Date: 18th July 2023
Your ref: 23/01233/OUT
My ref: 23/01069/CONSLT
Please ask for: Felicity Byrne
Telephone: (01865) 252159

APPLICATION: 23/01233/OUT

PROPOSAL: Outline application (with all matters except access reserved for future consideration) for the demolition of existing buildings and the erection of up to 800 dwellings (Class C3); a two form entry primary school; a local centre (comprising convenience retailing (not less than 350sqm and up to 500sqm (Class E(a))), business uses (Class E(g)(i)) and/or financial and professional uses (Class E(c)) up to 500sqm, café or restaurant use (Class E(b)) up to 200sqm; community building (Class E and F2); car and cycle parking); associated play areas, allotments, public open green space and landscaping; new vehicular, pedestrian and cycle access points; internal roads, paths and communal parking infrastructure; associated works, infrastructure (including Sustainable Urban Drainage, services and utilities) and ancillary development. Works to the Oxford Road in the vicinity of the site to include, pedestrian and cycle infrastructure, drainage, bus stops, landscaping and ancillary development.

AT: OS Parcel 4347 East Of Pipal Cottage,

Figure 11 – Illustrative Masterplan

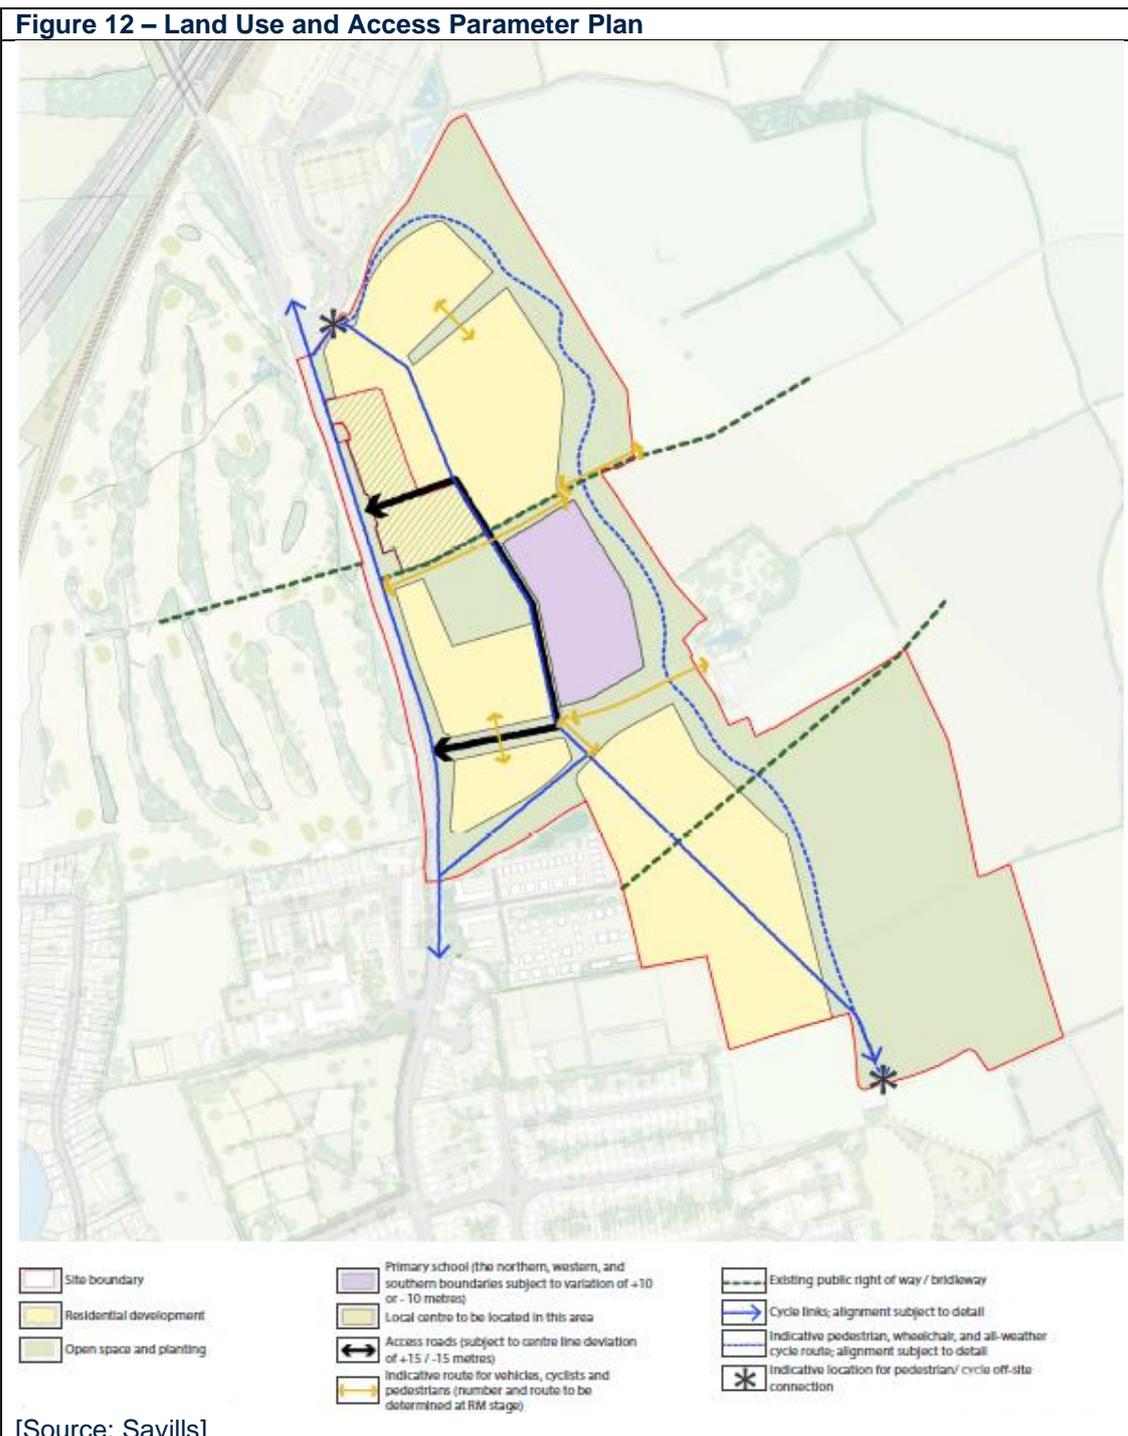
The illustrative Masterplan is noted. Under reserved matters it is considered that the development should high quality that responds to the character of Oxford. Careful consideration must be given to the urban grain, massing, appearance and materials.

It is imperative that the development connects the existing PRoW into the Croudace Scheme. However, your attention is drawn to the fact that the PRoW on the illustrative Masterplan may not be in the correct place. This needs to be discussed with Croudace at the earliest.

Figure 13 – Building Heights Parameter Plan

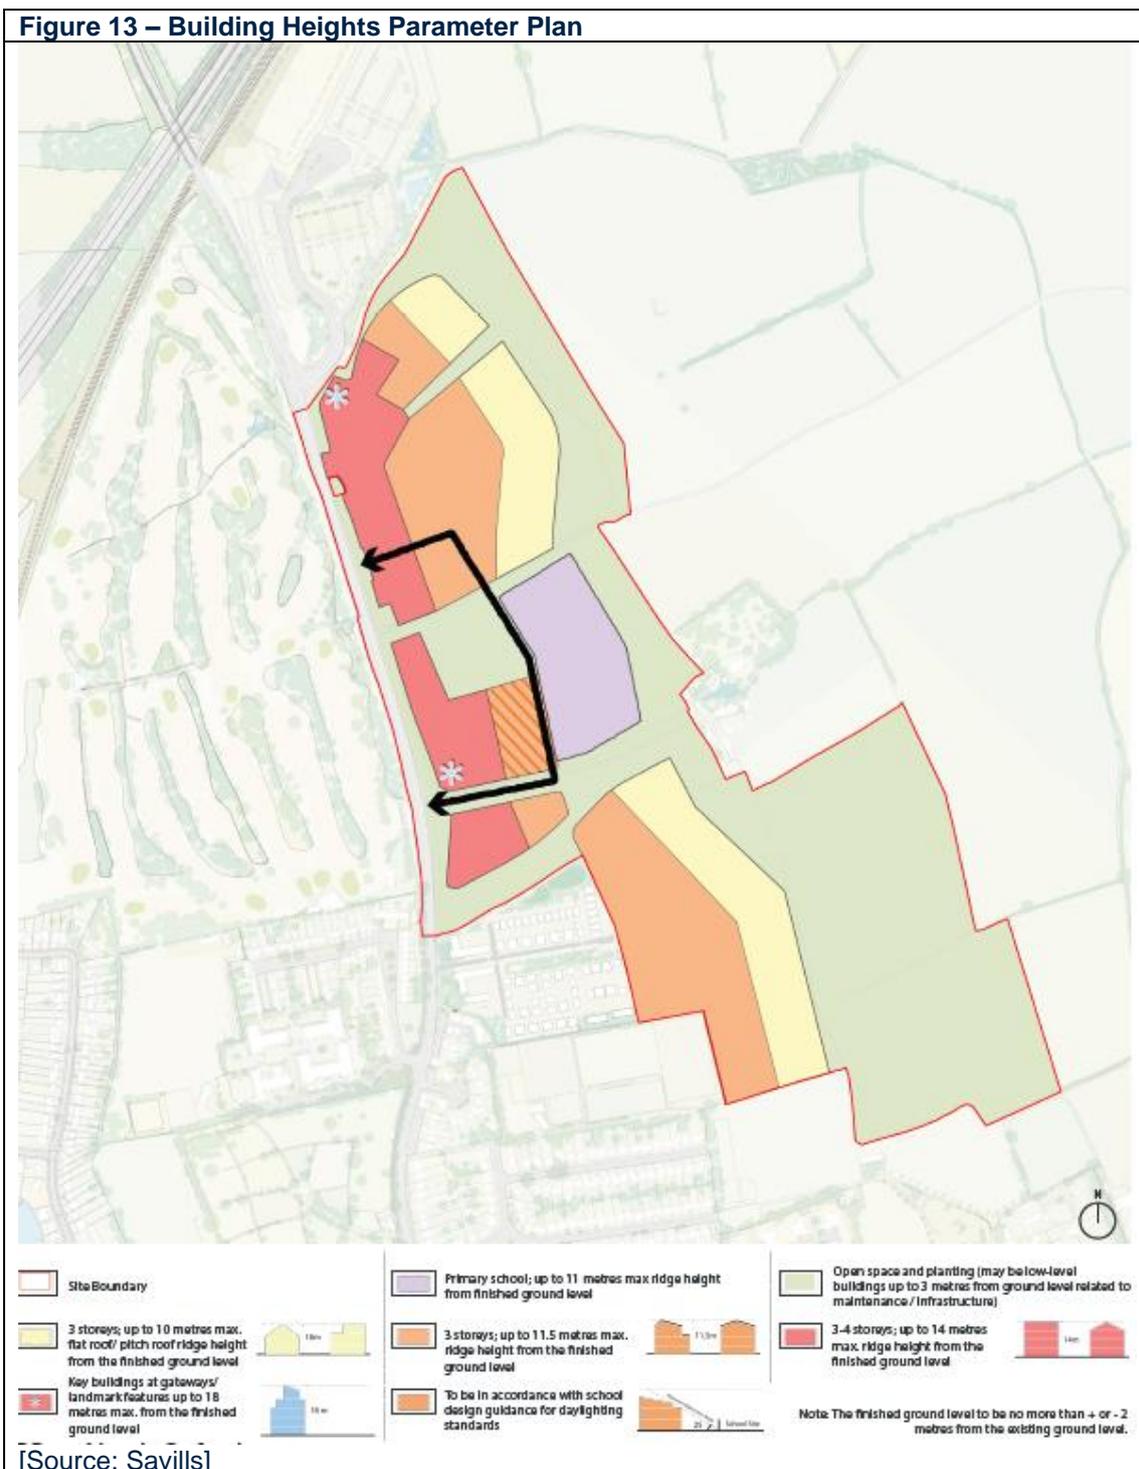
The submitted Parameters Plan and approach street hierarchy with key landmark buildings on corners is broadly supported (subject to detailed design considerations and assessments of views at reserved matters stage) with two exceptions:

- I. The Parameters Plan should be amended to make clear that the 'yellow' areas are

'two to three storeys up to 10m maximum in height'; The outer edges of the development should be 2 storeys with rooms in the roof to appropriately respond to the existing two storey housing within the adjoining Cutteslowe area and minimise impact in views from the surrounding landscape.

- II. New dwellings adjoining the Croudace Development (to the southwest corner of PR6a) should be restricted to 'two to three storeys and 10m maximum height' and therefore re-designated 'yellow' along this edge. This is to ensure an appropriate relationship to the two storey houses being built will be achieved. Where flats within the Croudace development adjoin PR6a then the designation could remain 'orange three storeys 11.5m height' (bottom south west corner of the Croudace Development).

Figure 14 – Green Infrastructure Parameter Plan

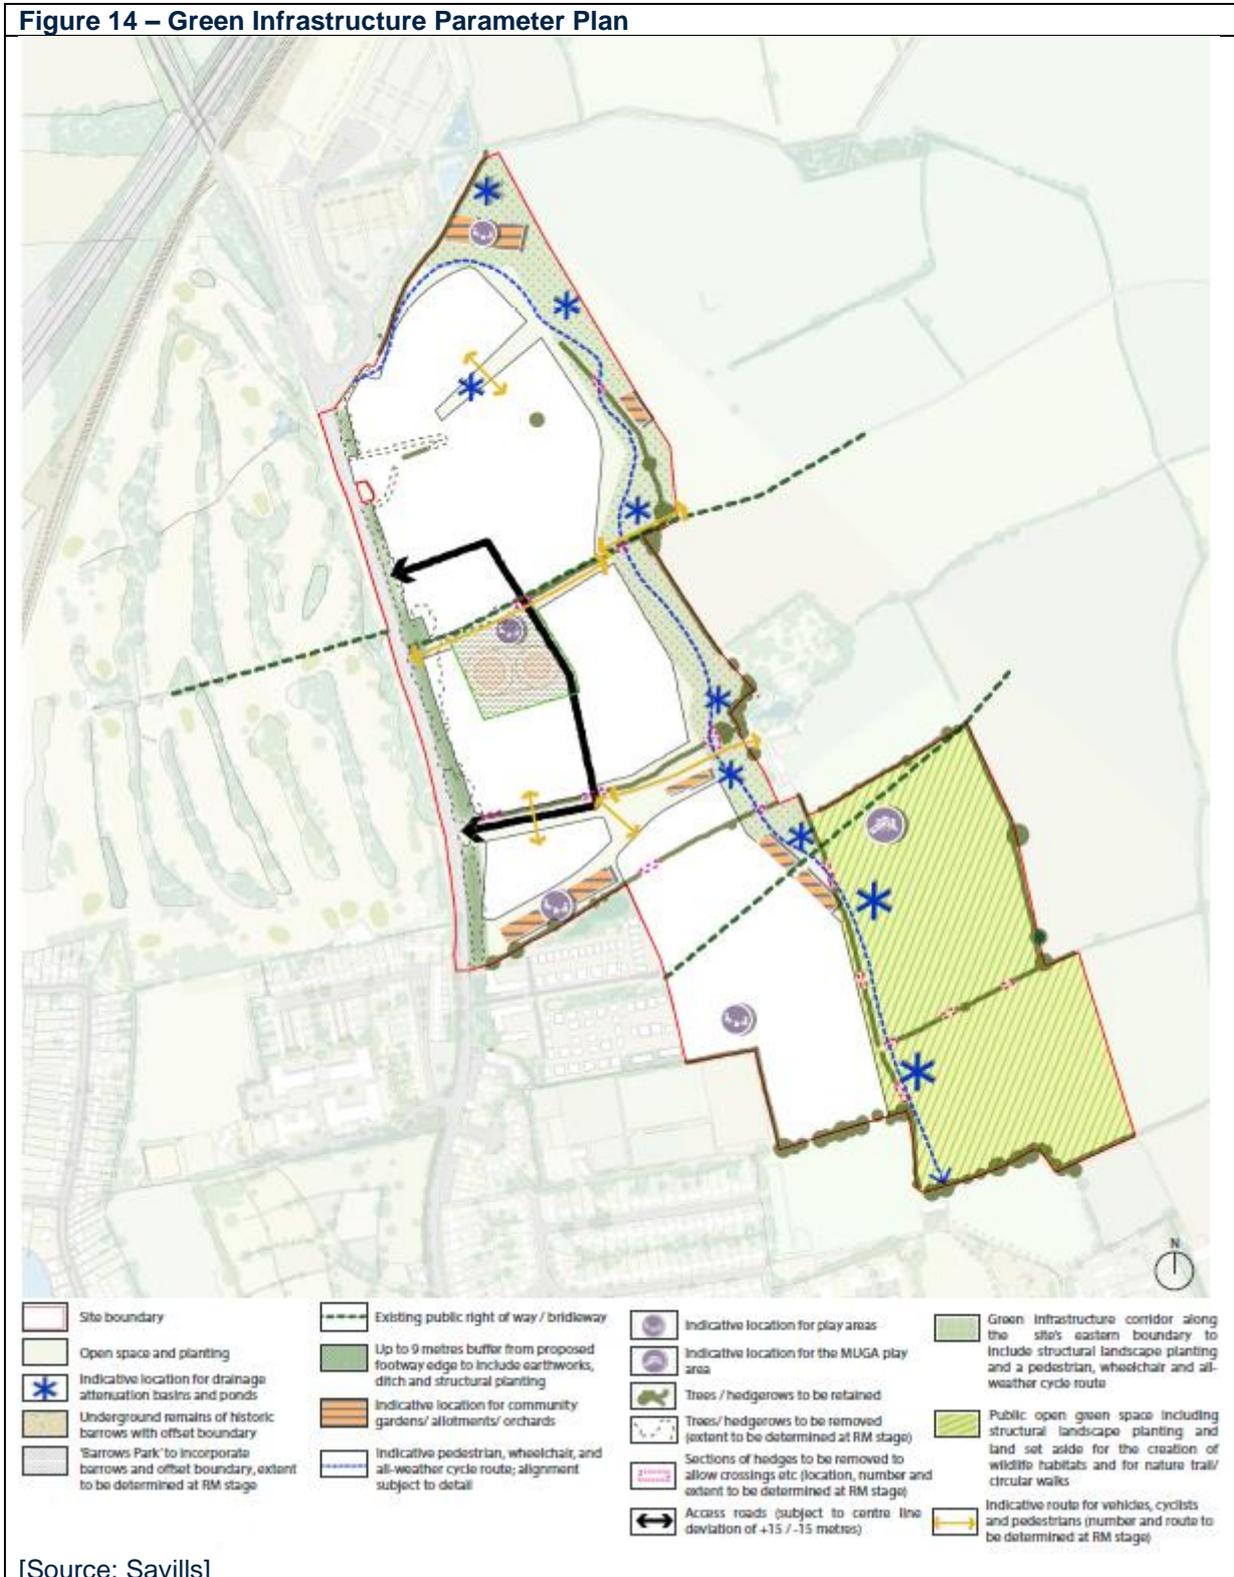
The approach to green infrastructure as shown on the Green Infrastructure Parameter Plan is supported. Significant existing trees and boundary vegetation appears to be retained and enhanced, which is welcomed. We would flag however that the area adjoining the northern boundary of the Croudace development that is designated for a play area and community gardens would abut the approved open space of that development. Whilst this is supported in principle there is indicated to be a substantial boundary vegetation belt along that boundary (an existing mature hedge currently exists and is retained). Substantial boundary vegetation would be undesirable if it forms a green wall barrier to integrating the two greenspaces of the developments. There is also an existing watercourse through this designated area. Careful consideration is therefore needed.

The Green Infrastructure Parameter Plan has sought to preserve the prehistoric/Saxon barrow site. As the application is located beyond the Oxford Local Authority Area (LPA) we defer to the advice of the County Archaeological Service. The impacts within the Oxford LPA are, based on present evidence, unlikely to have significant archaeological implication.
